Subject: FW: FP/137/20/DOC - Land On West Side Of Stanhorn Grove

You have both (EH and Ecology) raised concerns re the lighting proposed and in response I have received the attached email, amended lighting layout and the following text in italics:

Outdoor Lighting Report

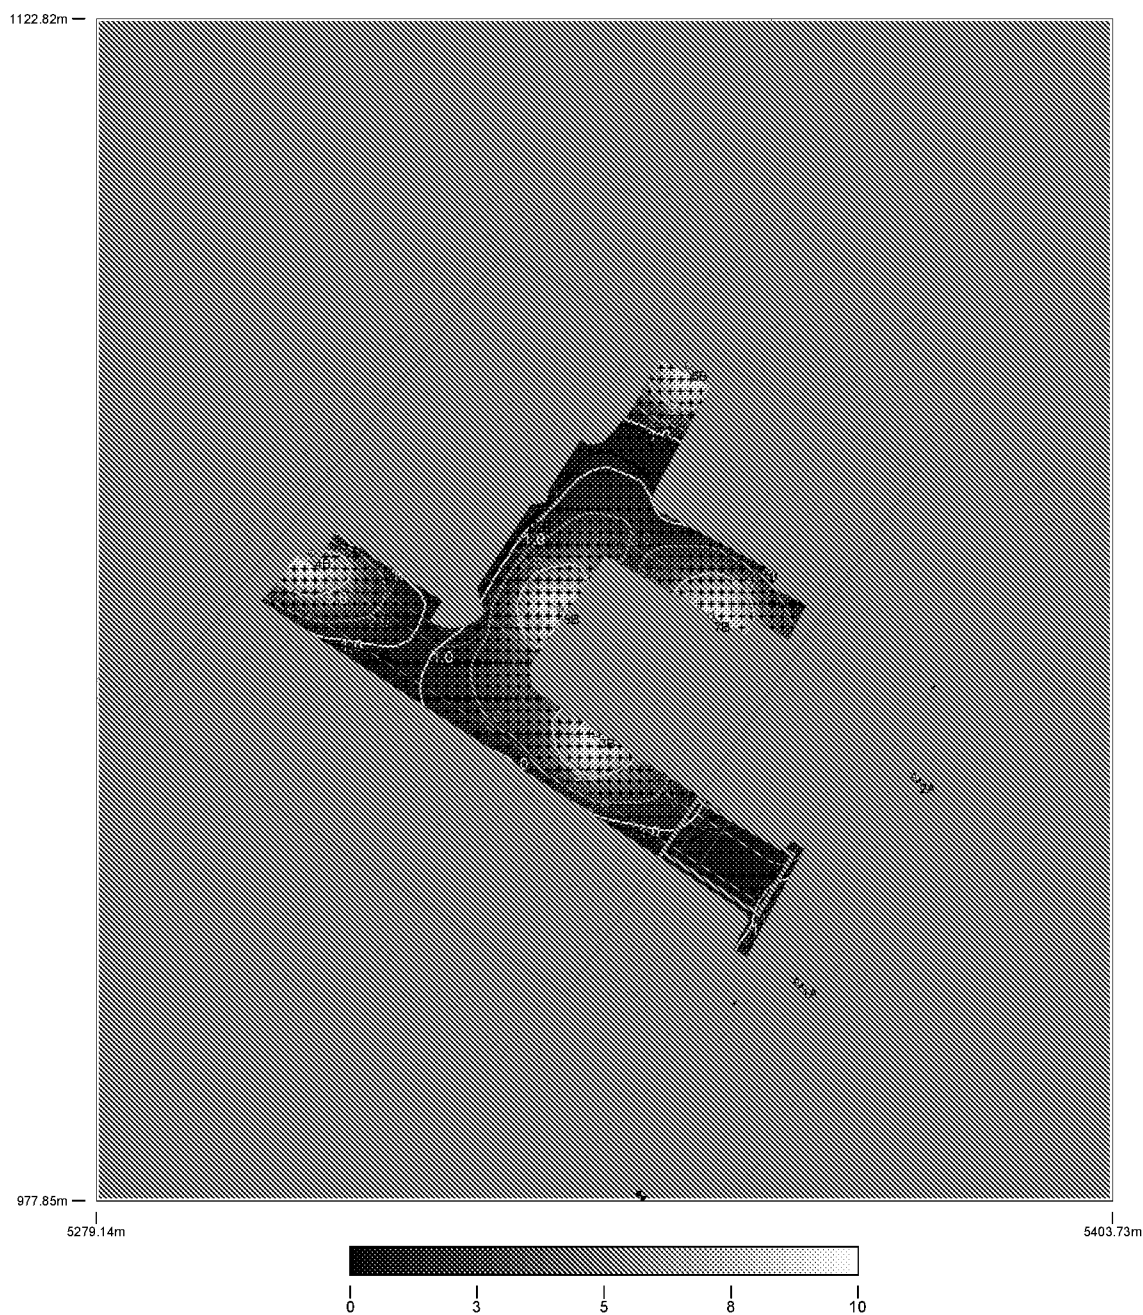
The 5 streetlamps and the fixed PIR lighting to dwellings has been designed with the ecology surveys in mind. I note the ecological assessment says a "sensitive lighting scheme" hence the minimal amount of columns. The report also states " Though several bat species take advantage of artificial lighting systems for foraging." And although the grassland provides a feeding ground for bats "the surrounding trees on site were considered to hold negligible potential to support bats due to lack of sustainable features" Trees have been retained however and enhancements made to not impact the bats however.
